WELWYN HATFIELD BOROUGH COUNCIL – ESTATE MANAGEMENT SCHEME
DELEGATED REPORT

APPLICATION No:	W6/2013/1279/EM
APPLICATION Site:	7 Densley Close, Welwyn Garden City

The proposal seeks estate management consent for a front porch, erection of a single storey side extension following demolition of existing incorporating an increase in its height, increase to its depth at the rear, four rooflights and a roof lantern and increasing the height of the existing side extension beyond the southern elevation.

Drawn By: DAMIEN Scale: 1:100 Date: APR 2013  
 City Status: PLANNING Checked:  
 Drawing No: 3018-P01 Revision:

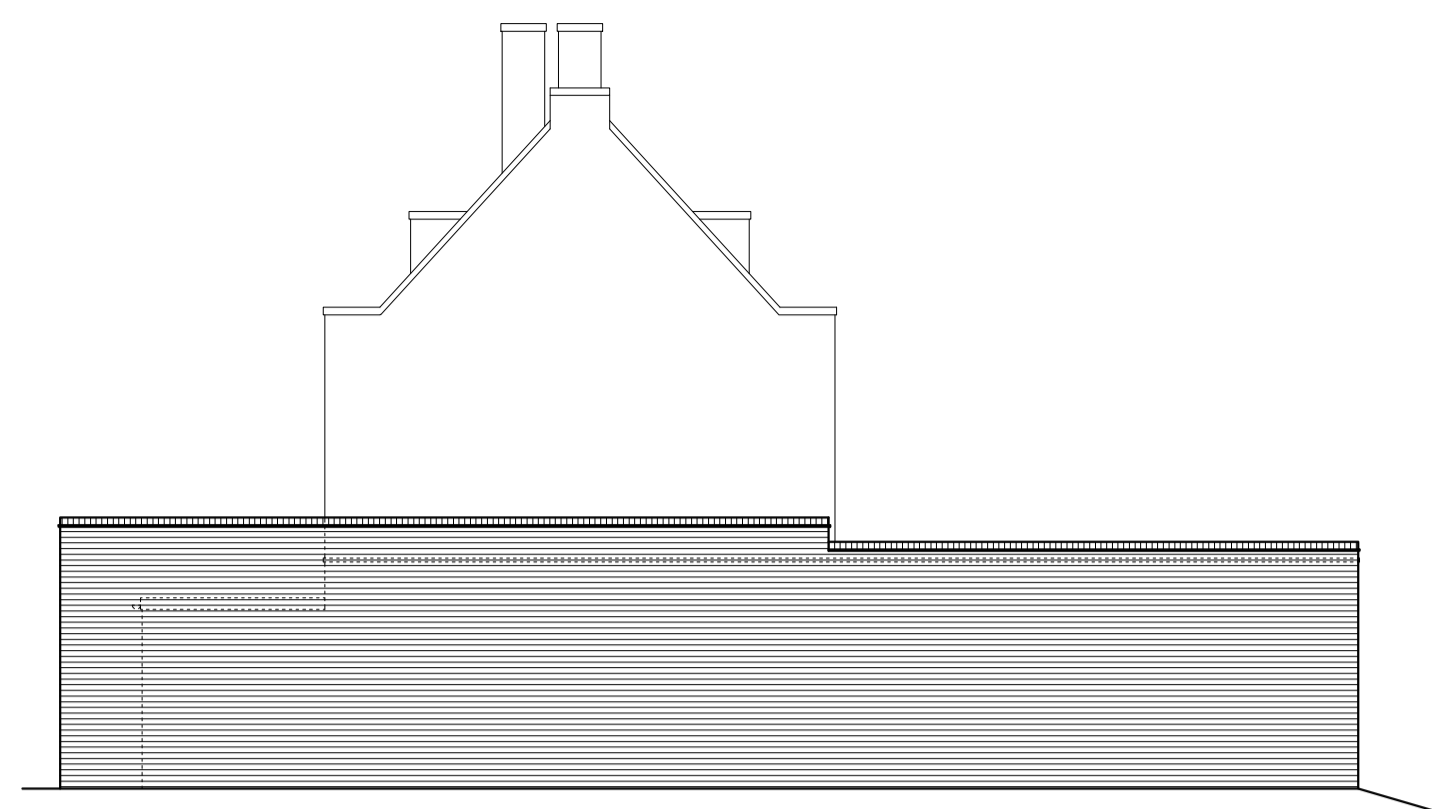
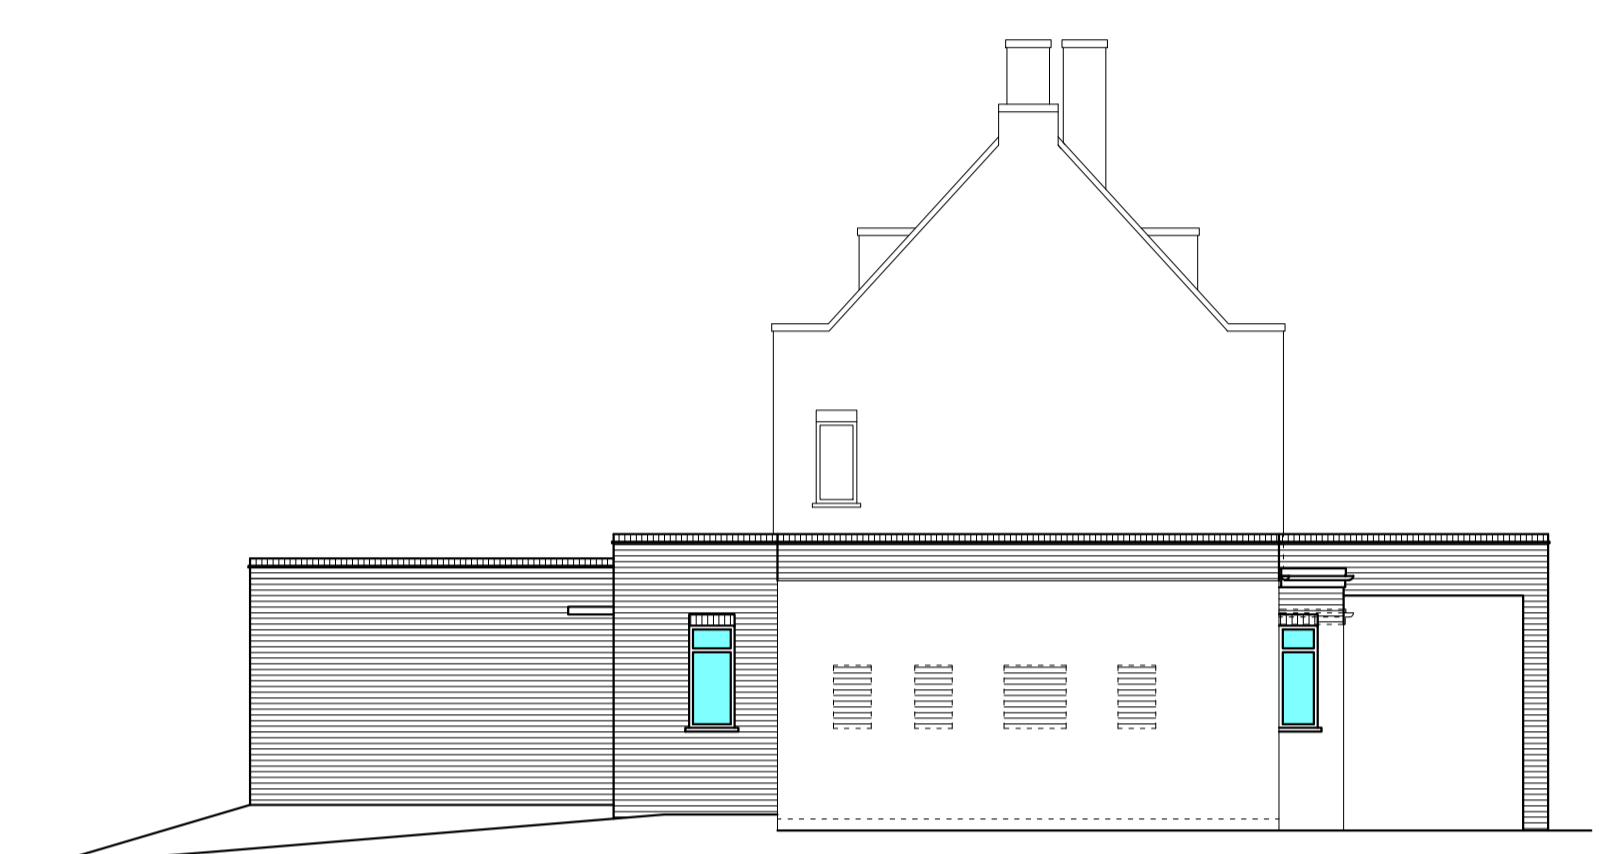
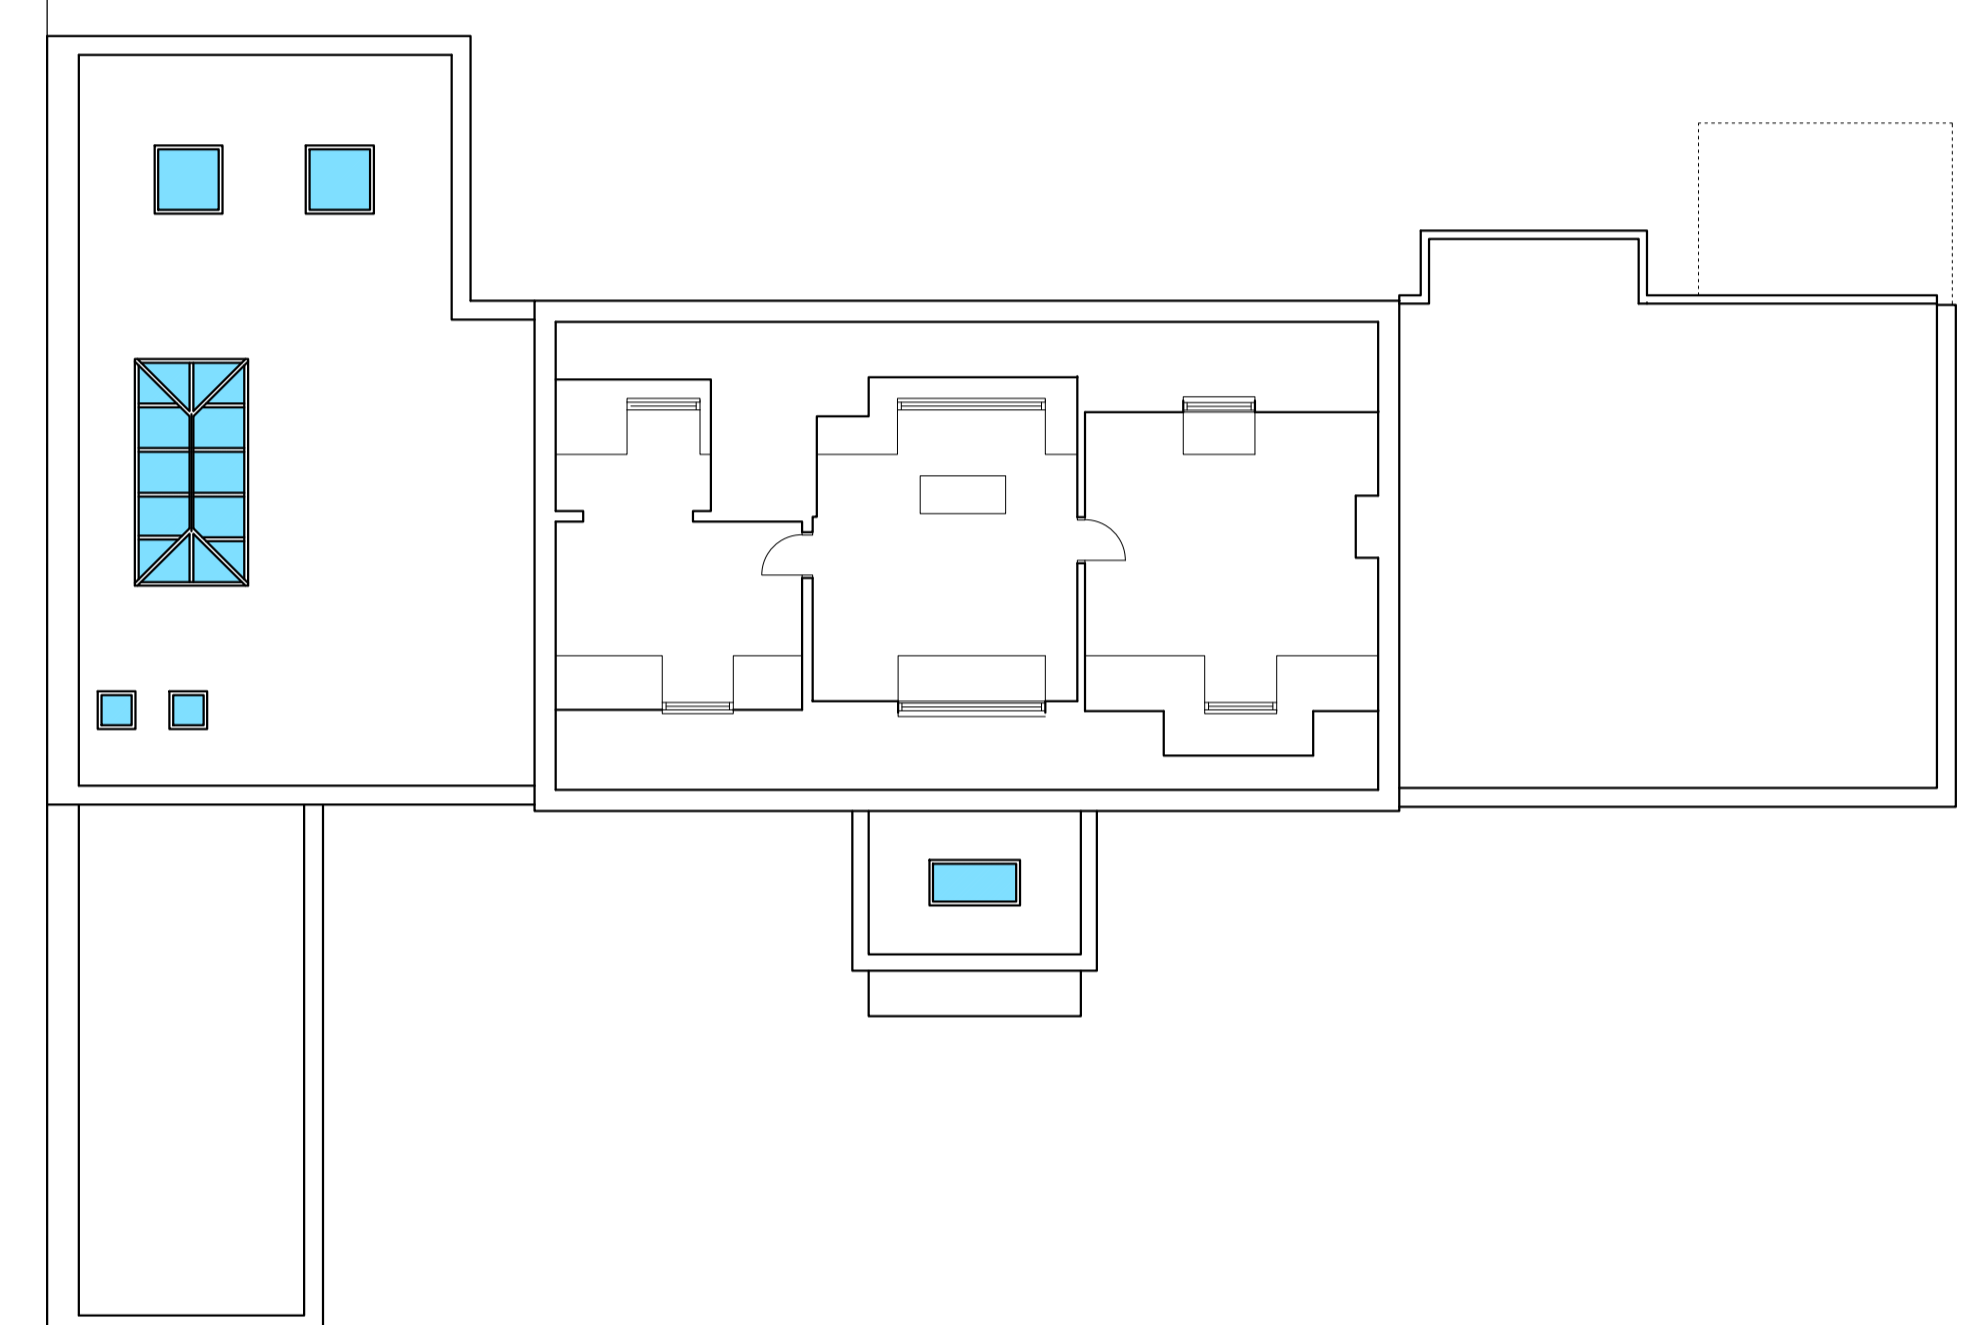
The proposal seeks to increase the height of the single storey extensions, both existing and proposed, to create parapet walls. The height of the existing garage is 3m with the proposed rebuild seeking to increase its height to 3.6m. Furthermore, the existing single storey extension attached to the southern elevation will increase in height by a further 0.55m. When viewed from the front elevation, the proposed height of the parapet walls will be near to the height of the first floor window sills which is unacceptable. It is noted that there are varying parapet heights of single storey extensions within Densley Close however, the poor arrangement of one extension should not be used to justify the similar design of another. Notwithstanding this, the proposed heights of the parapet walls would appear stark and overdominant within the streetscene.

Turning to the proposed front extension, the proposal seeks to extend upon the existing front canopy porch. The existing porch protrudes from the front elevation by approximately 0.5m with a canopy roof approximately 1.5m in depth. The proposal seeks to replace the front porch with a front extension approximately 2.1m in depth, at a width of 3.2m and a height of 3.8m. The overall scale of the proposed porch, in particular its height close to the window sill at first floor, would result in an overly dominant feature within the streetscene which would detract from the design and character of the dwelling and surrounding area.

1. The proposed front extension by virtue of its height, depth and overall scale and the proposed height of the two side extensions would appear

overdominant within the streetscene of Densley Close to such an extent that it would fail to maintain and enhance the amenities and values of the Garden City, contrary to policy EM1 of the Welwyn Garden City Estate Management Scheme.
